NSW RURAL FIRE SERVICE

Your reference: SSD 10422
Our reference: DA20200122000269-EIS & DA
Exhibition-1

Development Application

Berrima Brickworks Facility 416 Berrima Road Moss Vale NSW 2577, 1//DP785111, 1//DP785111

Figure 5 Asset Protection Zones – PBP 2006

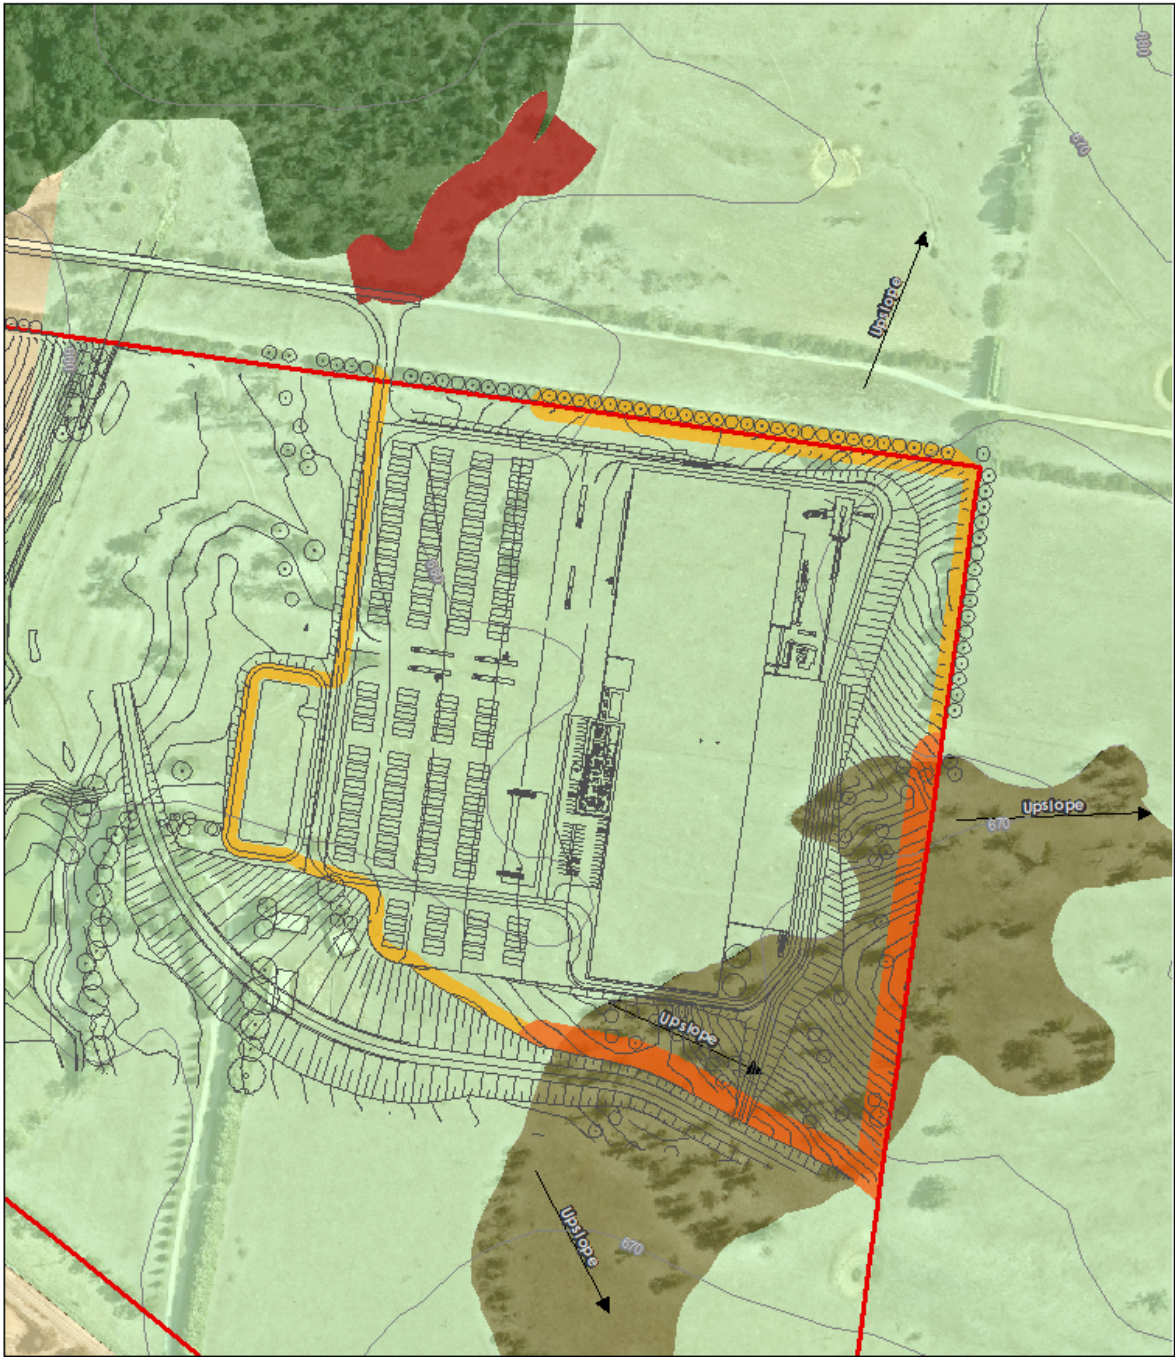
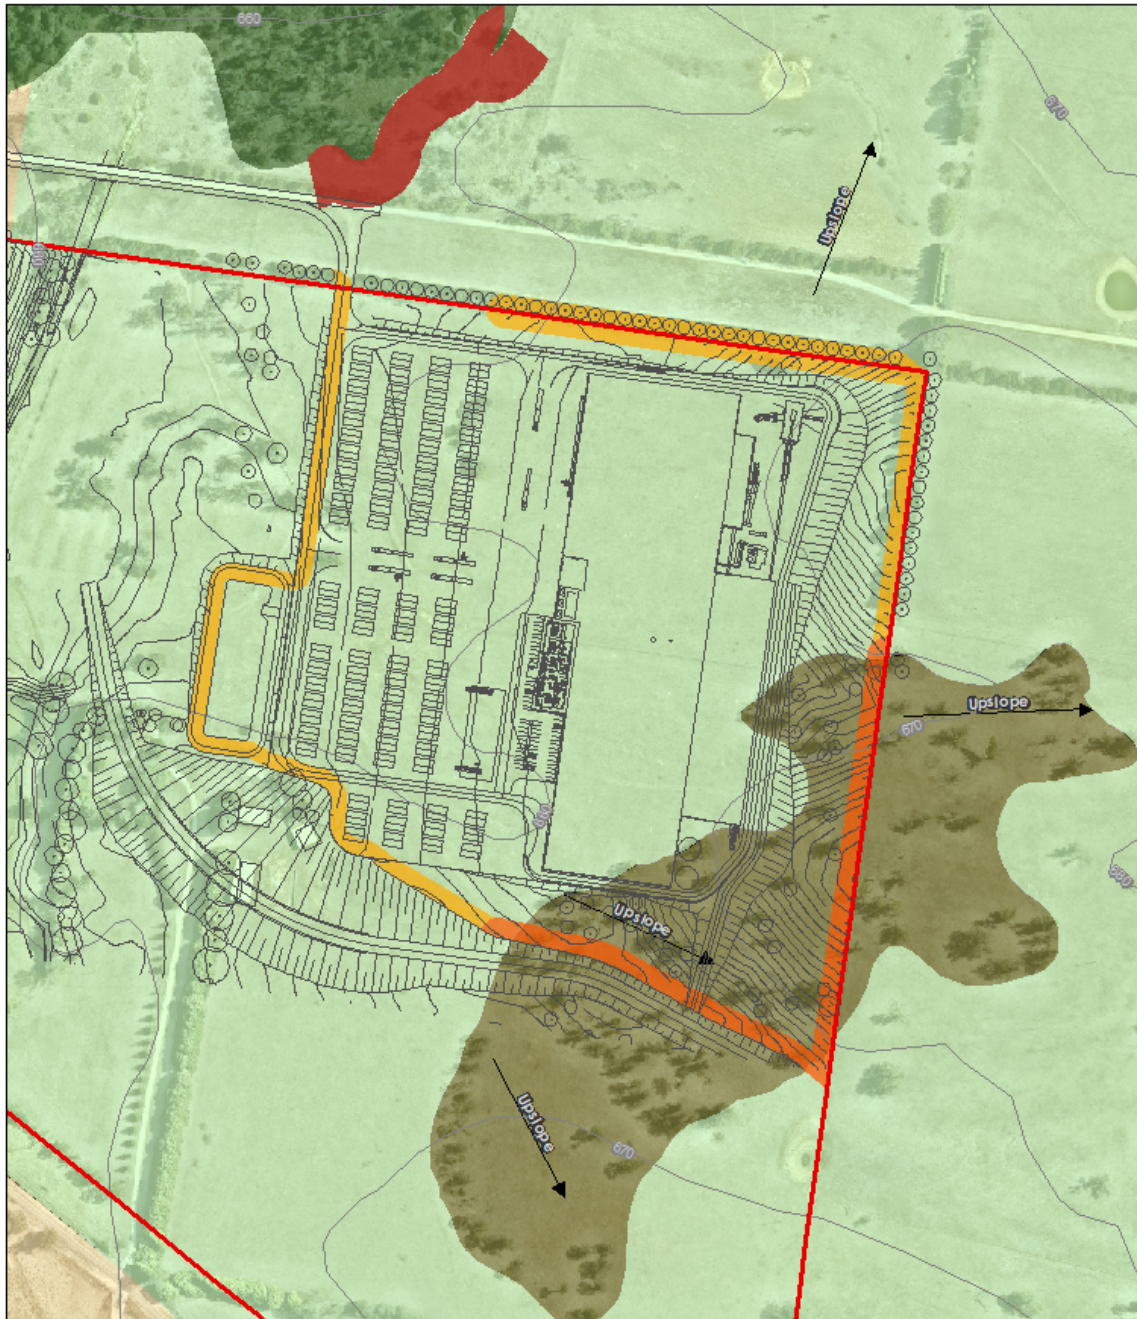
1. From the start of building works, and in perpetuity to ensure ongoing protection from the impact of bush fires, Asset Protection Zones (APZs) managed as an Inner Protection Area (IPA) must be provided as shown on the plan titled 'Figure 6 APZ – PBP 2019' provided by Blackash Bushfire Consulting (dated 17 March 2020, Ref: SSD-10422 Proposed Brickworks Plant (Plant 2)). The APZ should be extended from the proposed building to the property boundary on the eastern elevation.
